CITY OF PORTLAND, MAINE

PLANNING BOARD

March 17, 2015

Project Name: Midtown
Project ID: #2014-203
Address: 59 Somerset Street
CBL: 34-B-2, 3, 4, 5, 22 and 34-D-3, 9, 10
Applicant: FEDEQ DV001, LLC.
Planner: Richard Knowland

Drawing file: Civil - 3-9-18 / C-2.0A Overall Site Plan with Dimensions.pdf

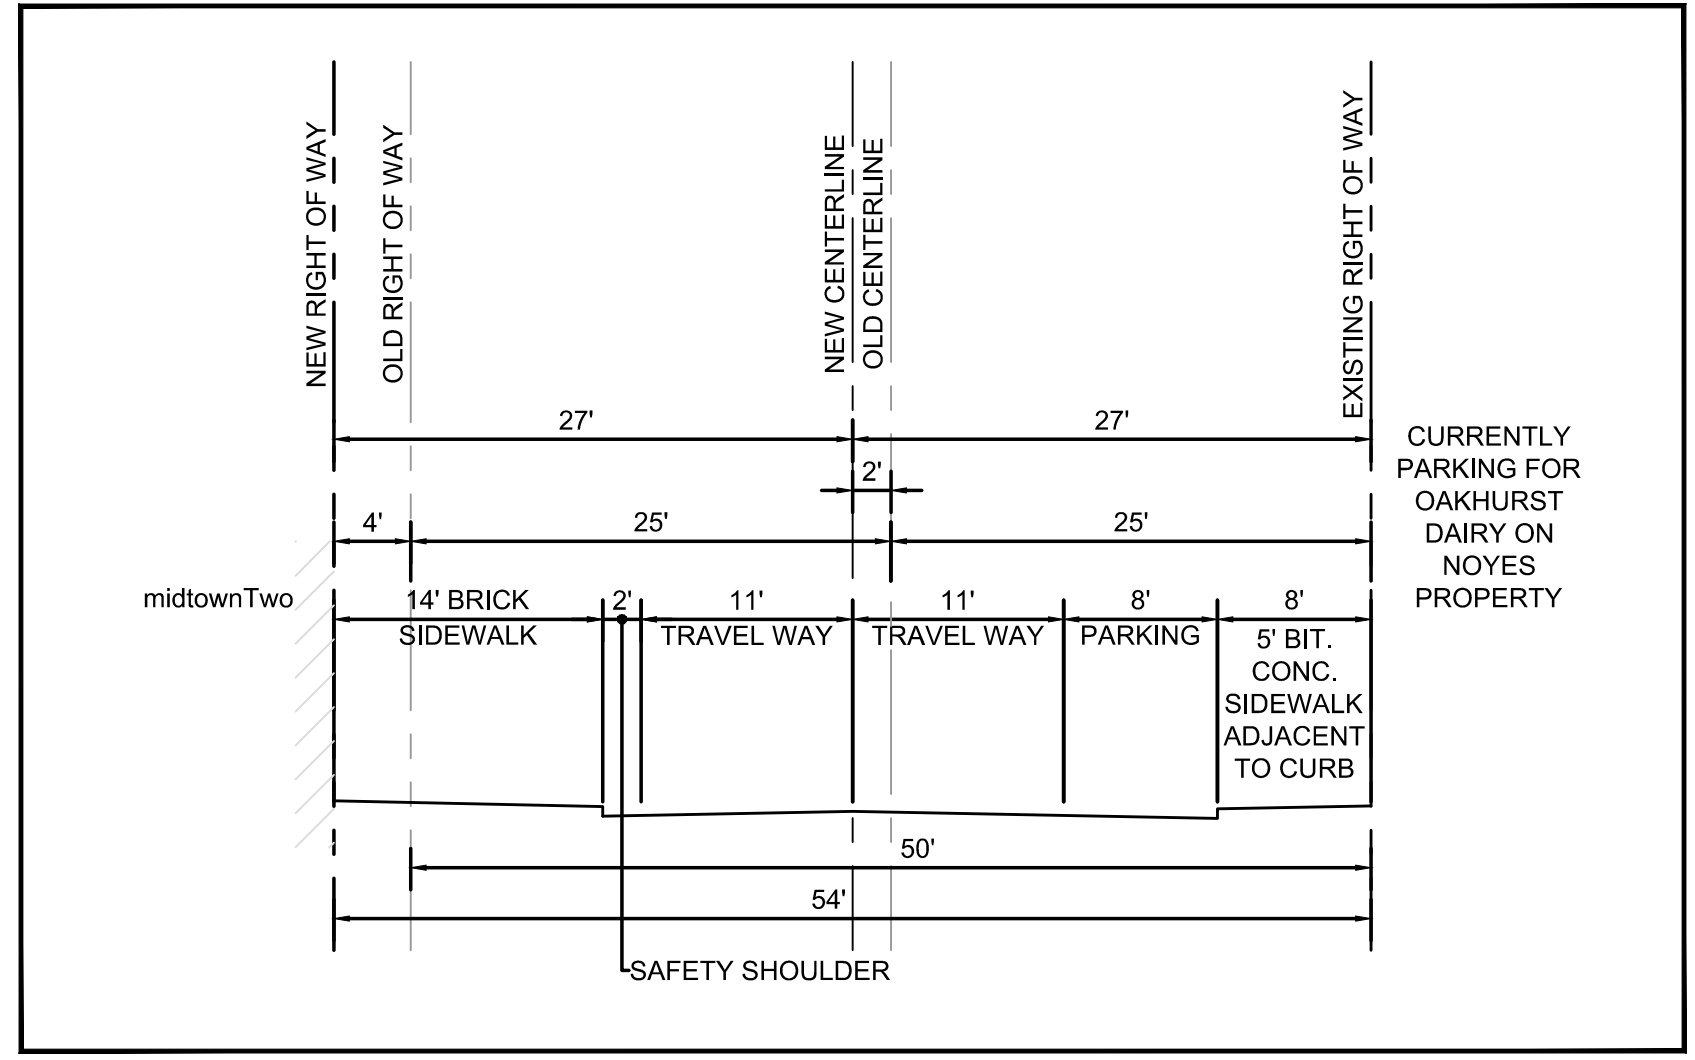
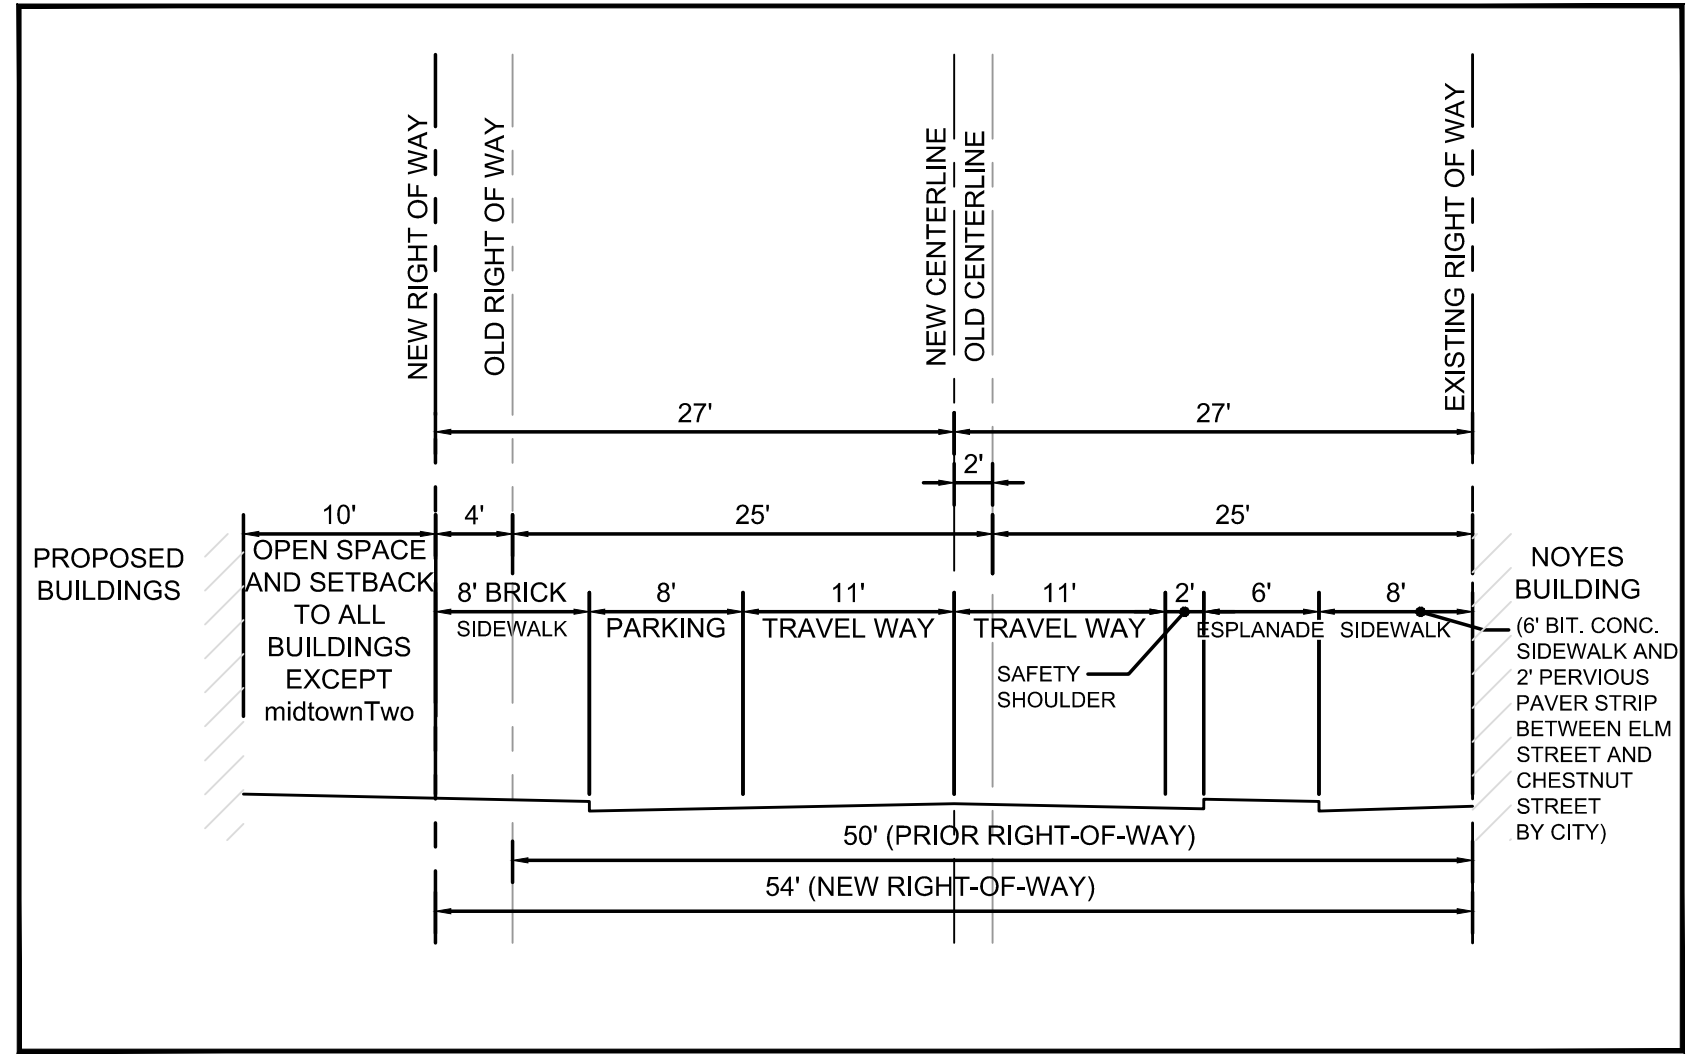
5. The curb extension on the north side of Somerset Street near the Mews must be extended to the beginning of the nearest on-street parking space along Somerset Street.

5. The curb extension on the north side of Somerset Street near the Mews must be extended to the beginning of the nearest on-street parking space along Somerset Street.

(E) BUS SHELTER AND SHELTER SITING LAYOUT
N.T.S.

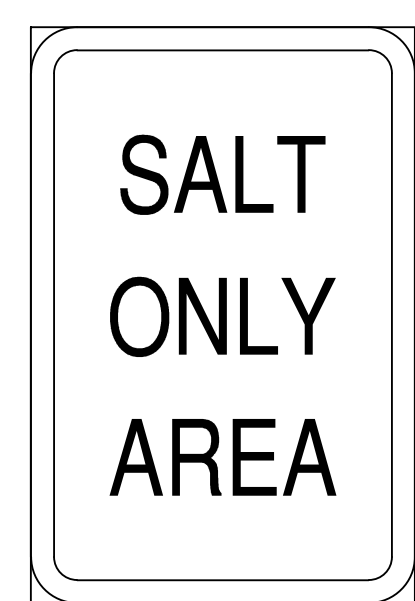
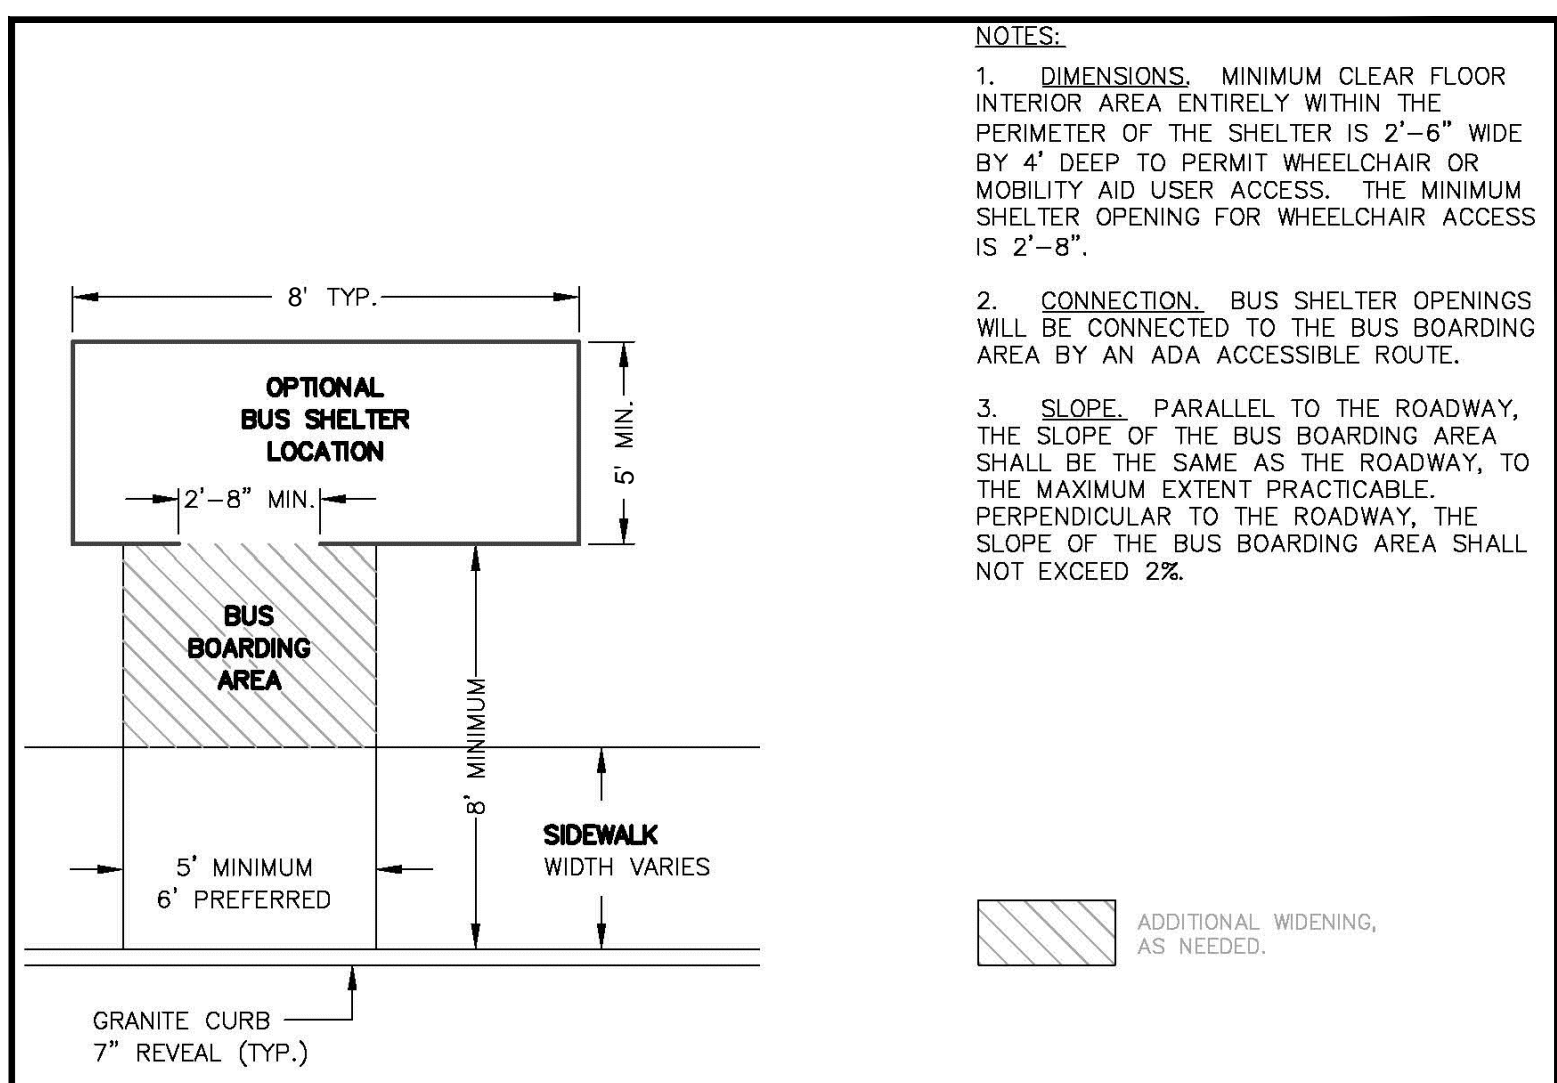
9. An in-line Transit Stop on Somerset Street is required and coordination with METRO is required to finalize details for the bus shelter. The proposed bus stop location does not provide the required ADA-compliant bus stop landing area (5'x8') nor does the bus stop directly connect to the ADA-compliant pedestrian access route at this location (per drawing C-2.0B). The final plans must address ADA compliance and the applicant must confirm that METRO has reviewed and approved the location.
